23 April 2012

**RE: APPLICATION NO: 3/2012/0247
CAR PARK FOR SYCAMORE BUNGALOWS, GISBURN**

Please be advised that Gisburn Parish Council wish to object to the above application

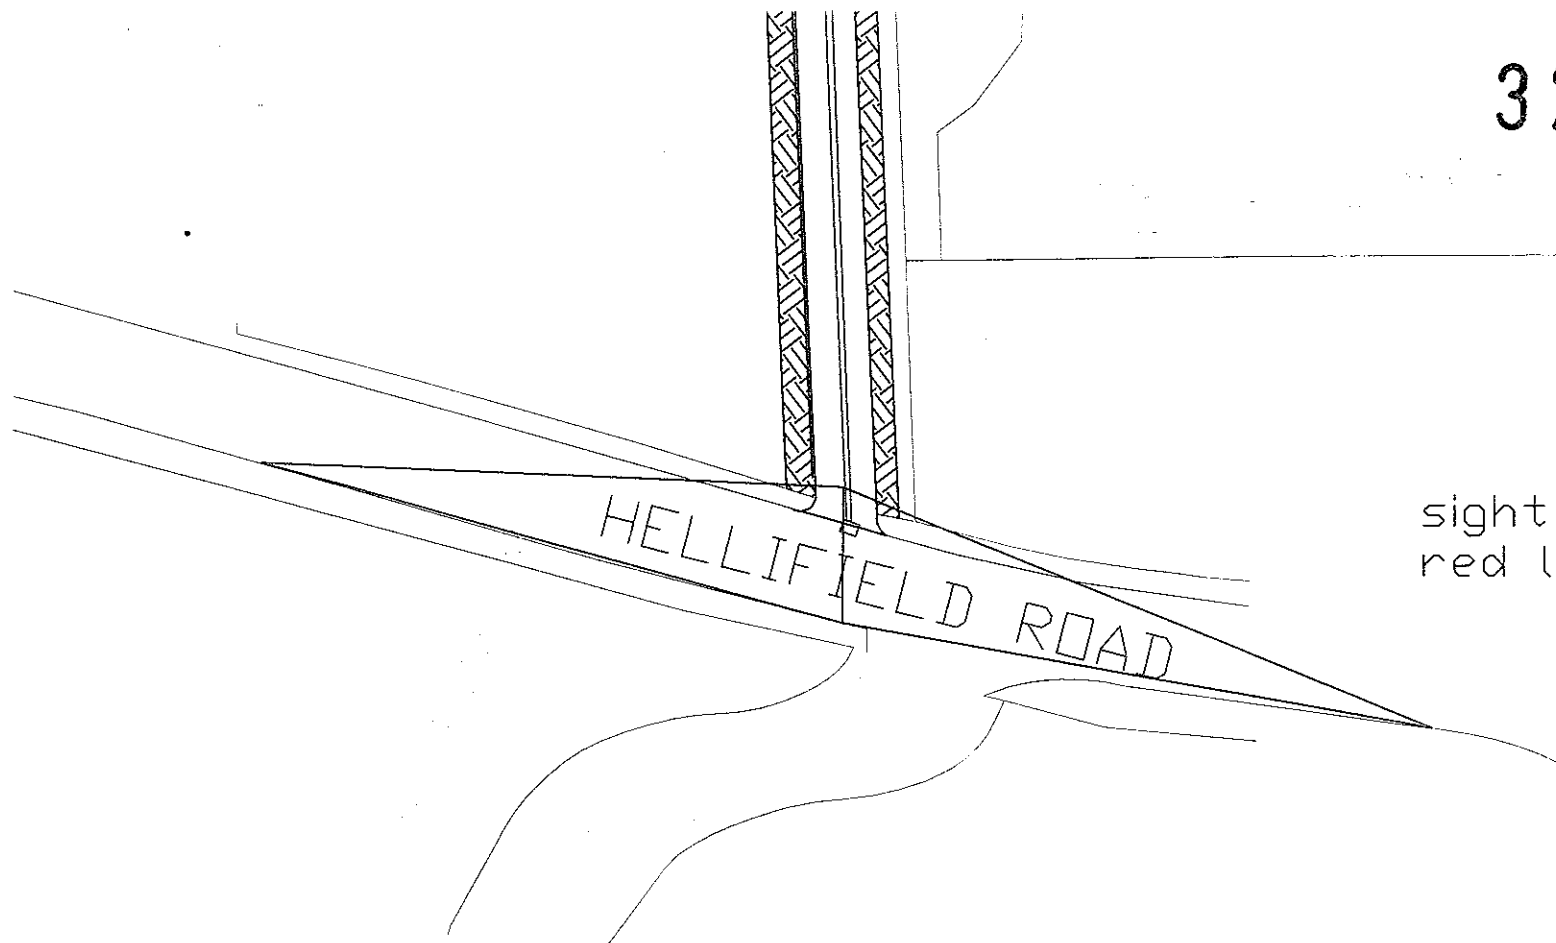
Firstly, the Parish Council do not understand why the proposal is for a car park at the rear of the properties when there is adequate land in front of the bungalows which could be used for the same purpose. Currently, the area in front of the bungalows is only used as lawn. It would be more sensible to devise plans for a car park using this area rather than a greenfield site at the rear.

Secondly, the Parish Council do not understand why access should be any easier to the properties from the rear as there will still be a need for a steep flight of steps. At present, there are two short flights of steps and a tarmac ramp; steeper steps would therefore be more difficult than the current arrangements at the front of the properties.

Thirdly, access to the proposed car park to and from the A682 is going to be potentially very dangerous. The A682 is one of the most dangerous roads in the country and is extensively used by large HGVs and fast motorbikes, as well as ordinary cars, all of which approach the mini-roundabout in Gisburn, near the proposed entrance, far too fast on occasion. The Council feels that having a car park access here is "an accident waiting to happen". The situation with danger is compounded at this location on certain days when there is an event at Church as churchgoers are obliged to park on the road as there is no Church car park. If larger vehicles are unable to turn round in the new car park they will also be compelled to reverse onto the A682 which will be even more dangerous.

Fourthly, during the winter months, use of the car park could be curtailed by the fact that it is going to be unlit and access could be difficult in icy or snowy conditions unless appropriate measures are to be taken to deal with these situations. Again, if a car park was to be constructed at the front of the properties there is street lighting on the A59 and there would be no access road required so gritting would not be an issue.

Sixthly, we are led to believe that drainage in the vicinity is not good at present and further development could exacerbate an existing poor situation.
